## PLANNING CONSULTATION RESPONSE

<b>Application No</b>	2025/0908
<b>Proposal</b>	Re-engineering and Restoration of Yew Tree Quarry through the importation of non hazardous Excavated Soil Materials
<b>Address</b>	Stairfoot Brickworks, Wombwell Lane, Stairfoot, Barnsley, S70 3NS
<b>Date of Consultation Reply</b>	30/03/2026
<b>Consultee</b>	Highways Development Control

Proposed Site Access Arrangements

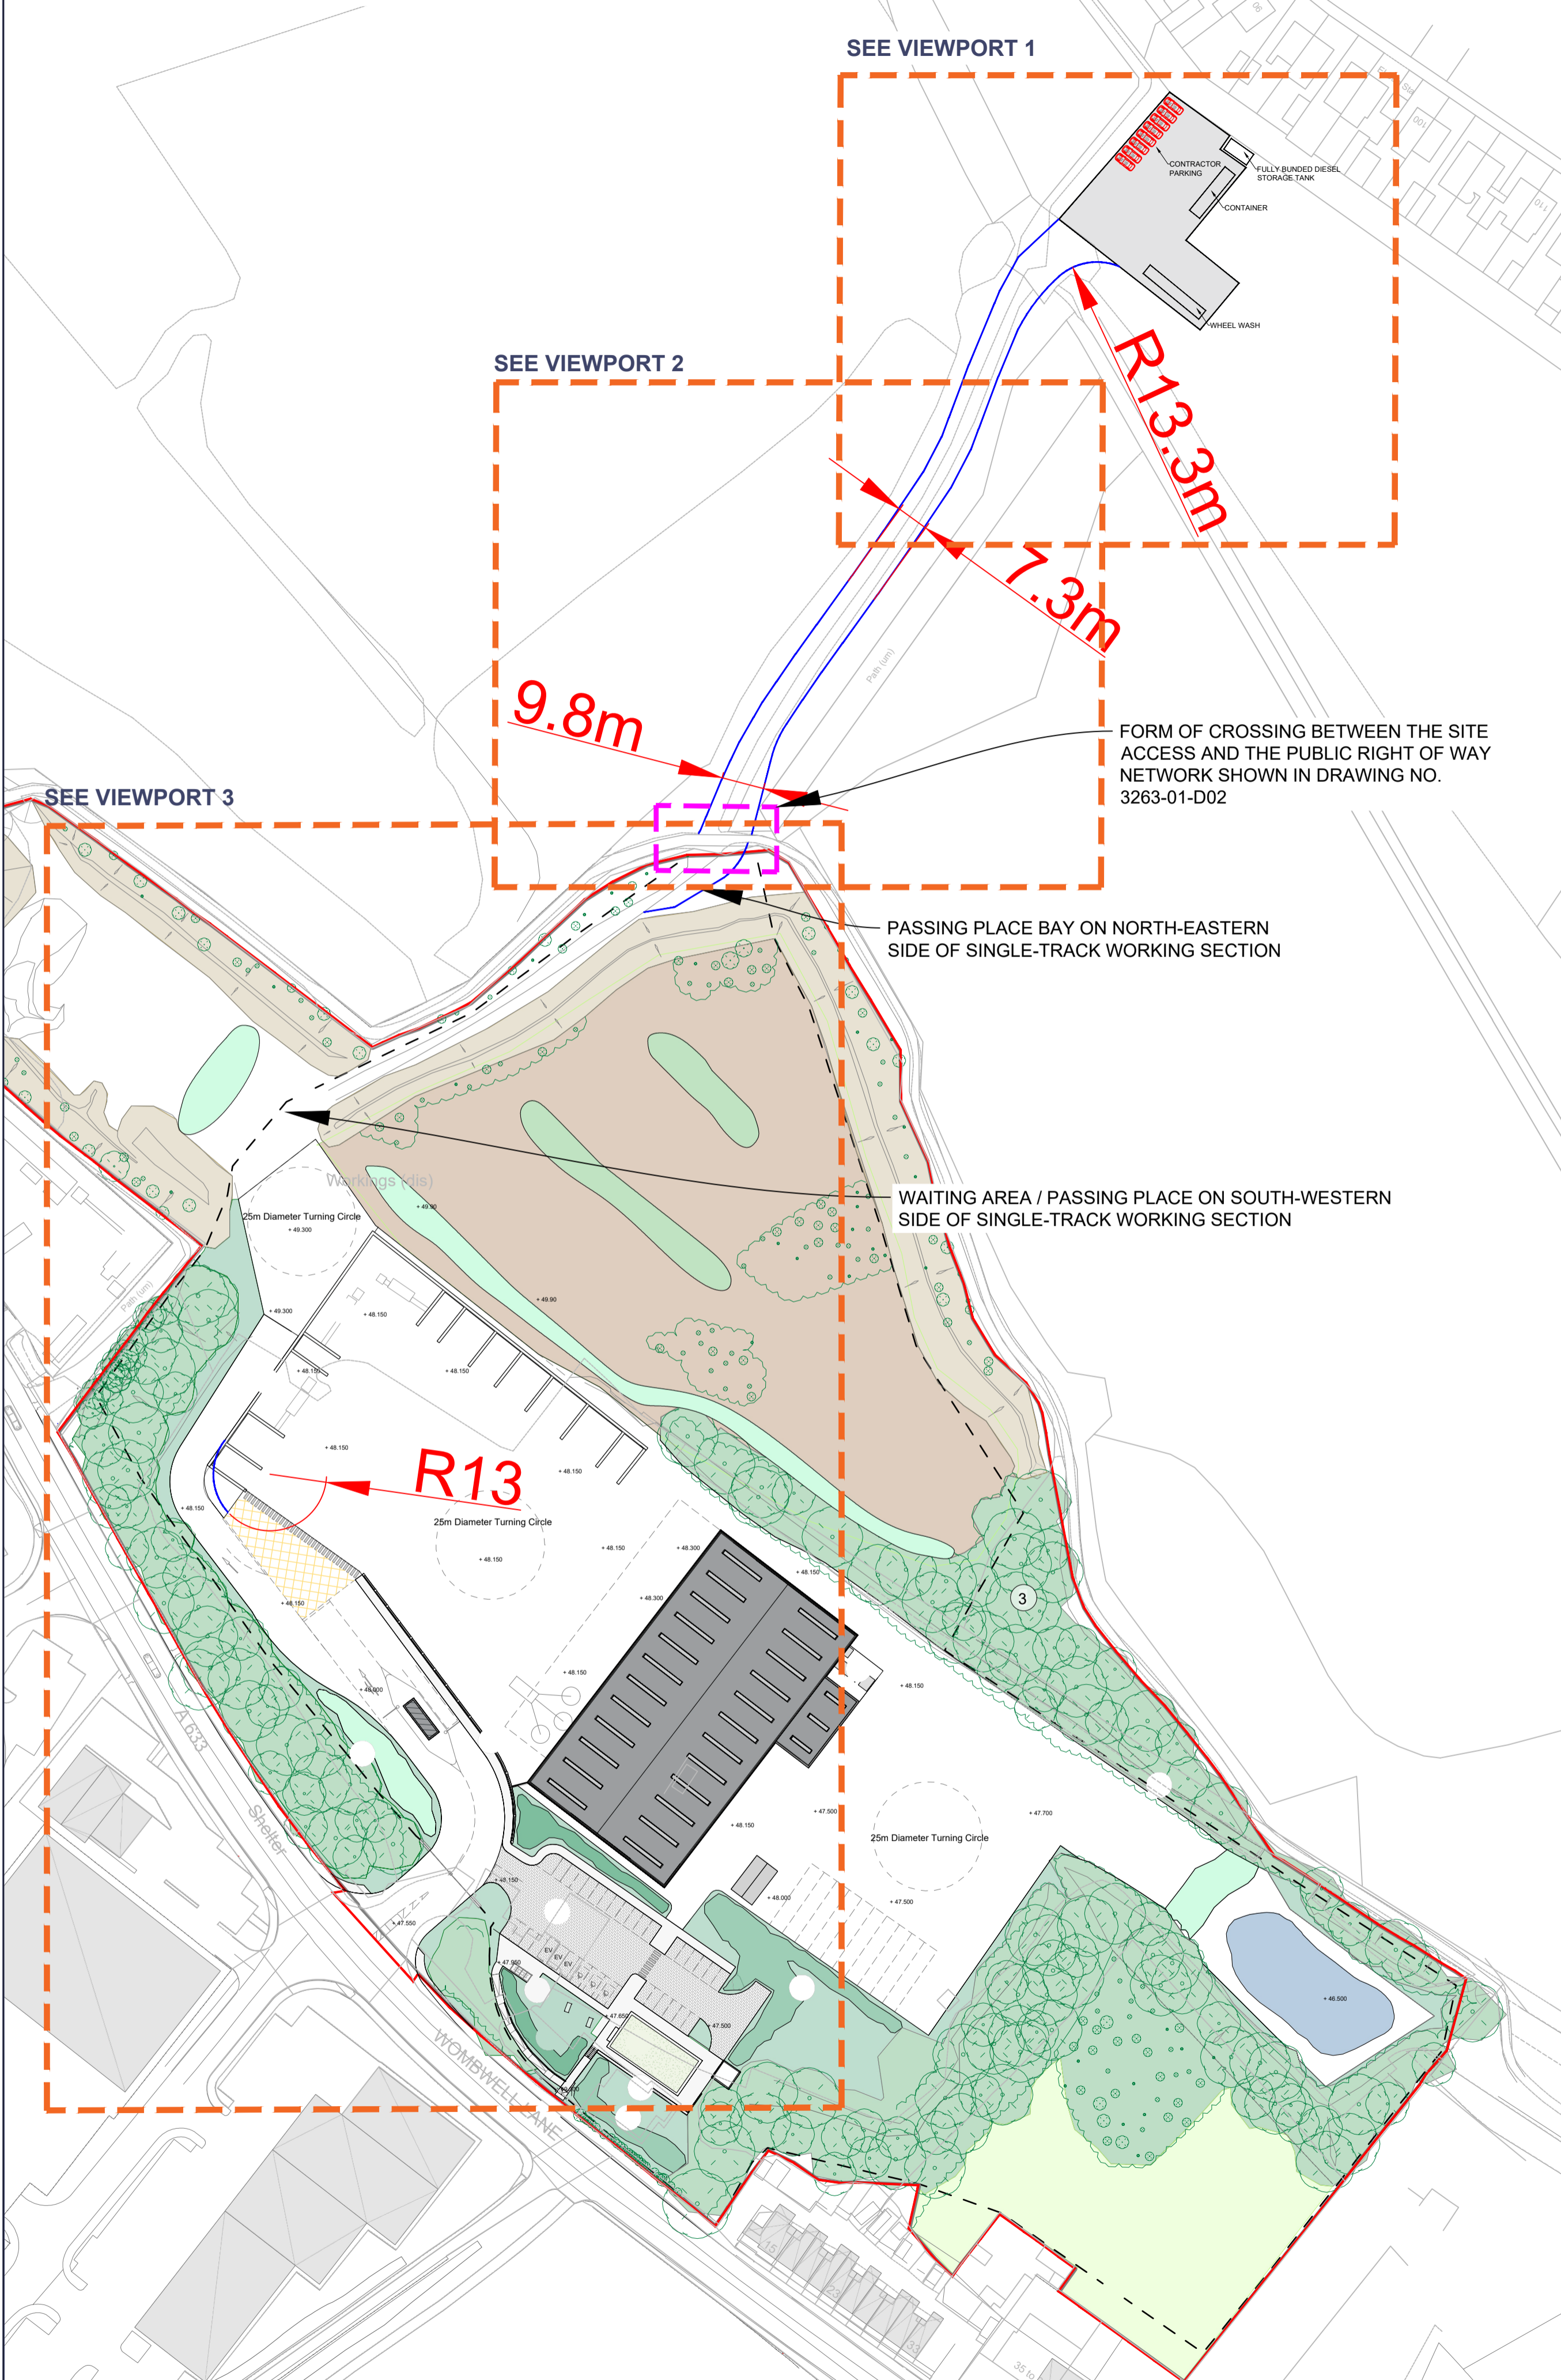
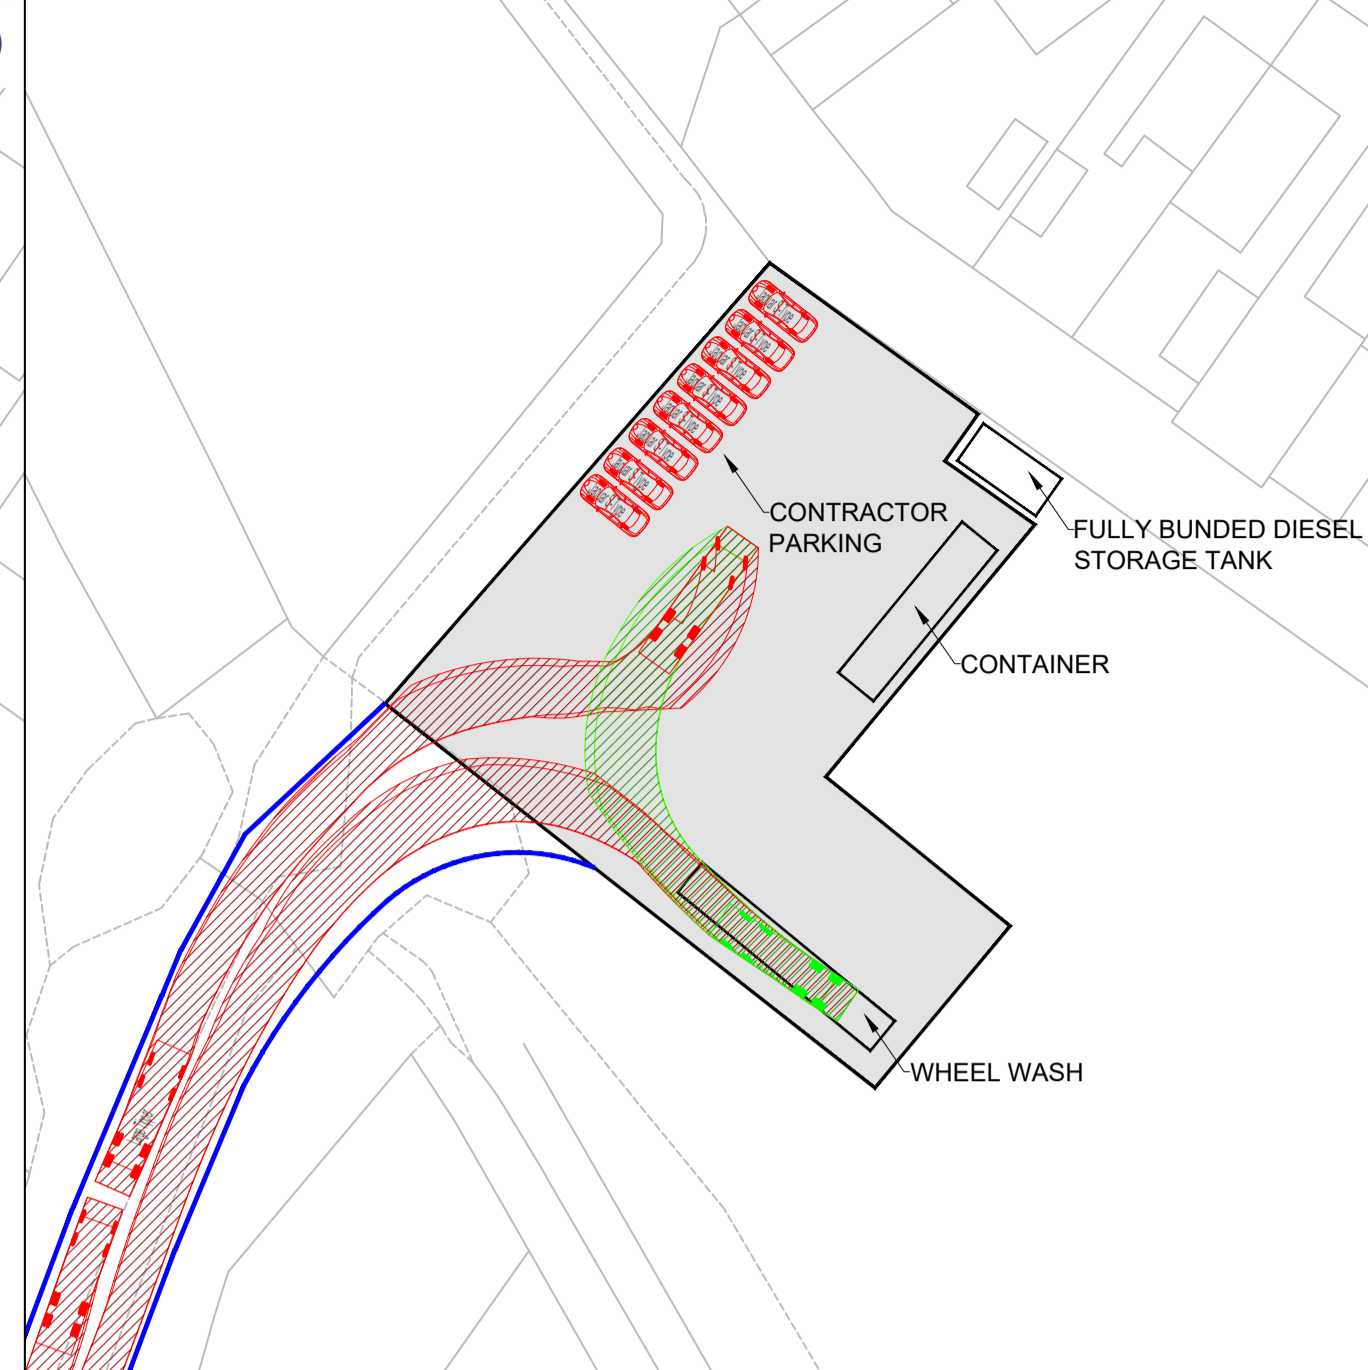
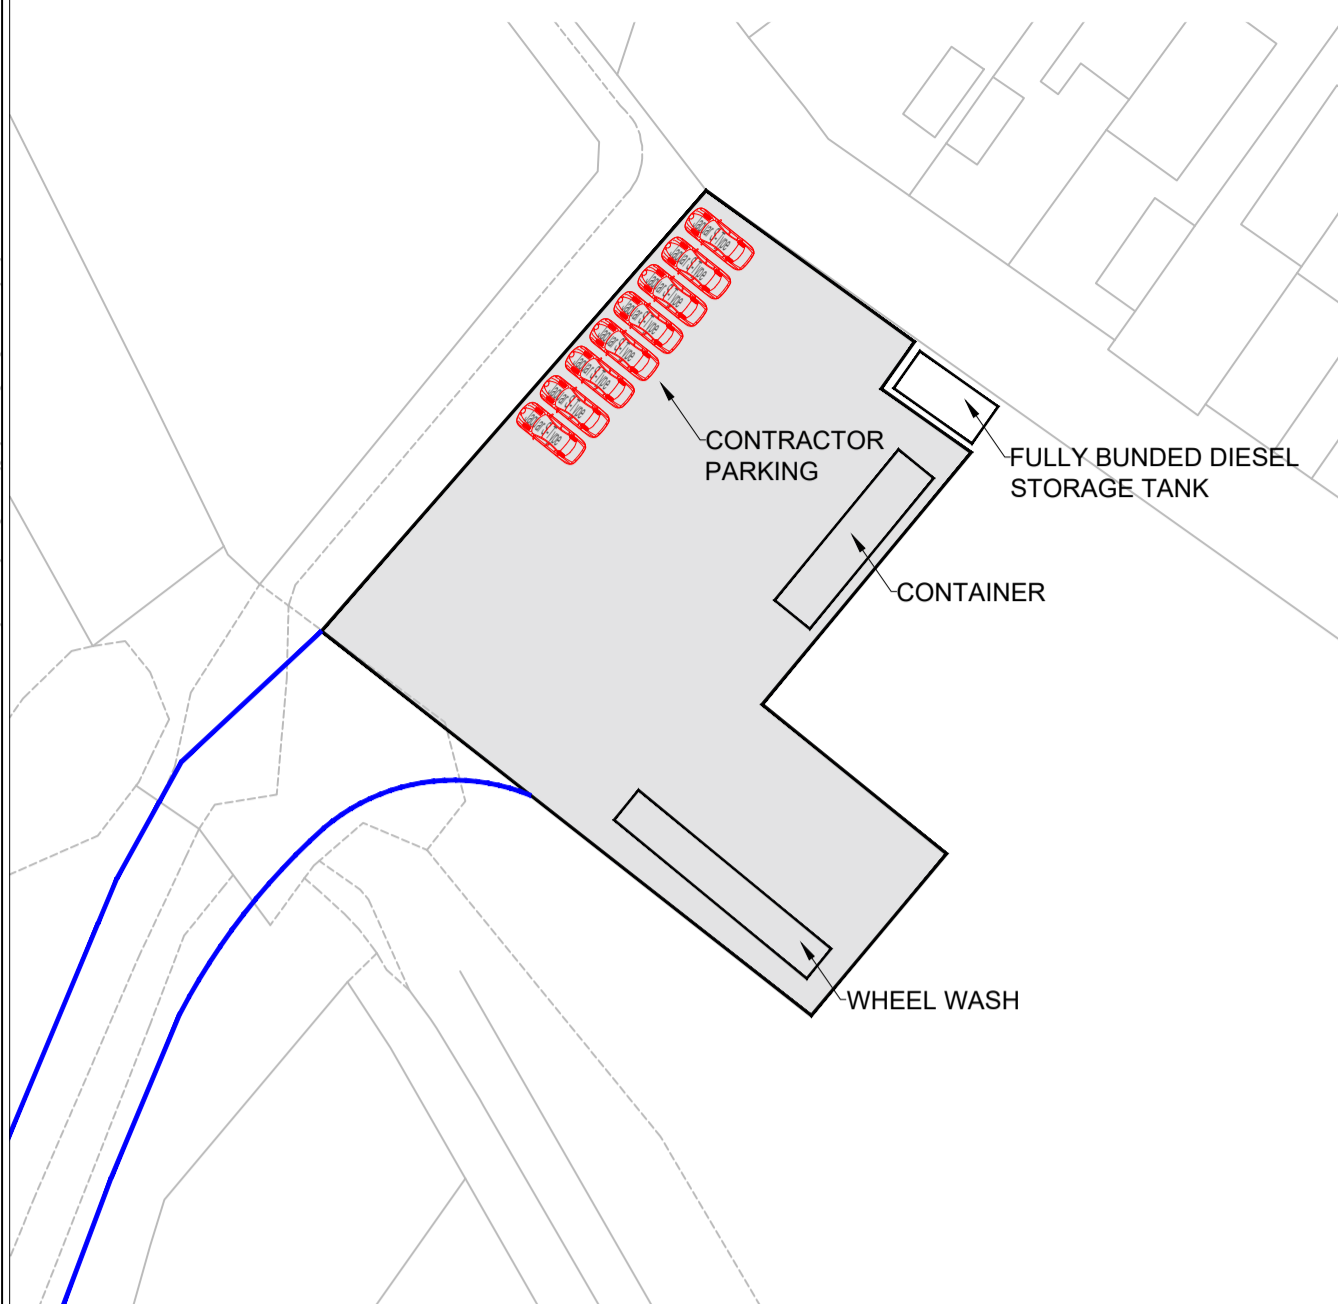
I note that the applicant is reliant on the site access works being brought forward and completed by the site owners of the former Stairfoot Brickworks site. However, at present, works to construct the access to an approved standard have yet to commence. This introduces a degree of uncertainty in relying on the proposed access arrangements to manage vehicle movements safely and effectively. Furthermore, I note within sections 4.2.4 and 4.2.5 of the delivery management plan, it states -

This clearly indicates that platoons of up to 5 or 6 HGVs could arrive at the site at the same time, with the potential for up to 11 vehicles to arrive at the same time. Given that the access arrangements are linked to the wider former Brickworks permission, I would also query whether sufficient consideration has been given to the combined vehicle movements arising from both sites operating concurrently. As you will be aware, a gated access was approved, with the gates set back to accommodate a single waiting HGV only. Any additional vehicles arriving at the same time would therefore be required to wait on the public highway, which would be likely to result in

disruption to the free flow on traffic on what is a sensitive and heavily trafficked section of the local road network.

On this basis, I remain concerned that the proposed delivery and access arrangements, as currently presented, do not adequately demonstrate that HGV movements can be managed without giving rise to potential highway safety or operational issues. Consequently, at the present time I would be required to raise an objection on this basis or alternatively request that you defer a conclusion pending the submission of any further information capable of addressing the issues identified above.
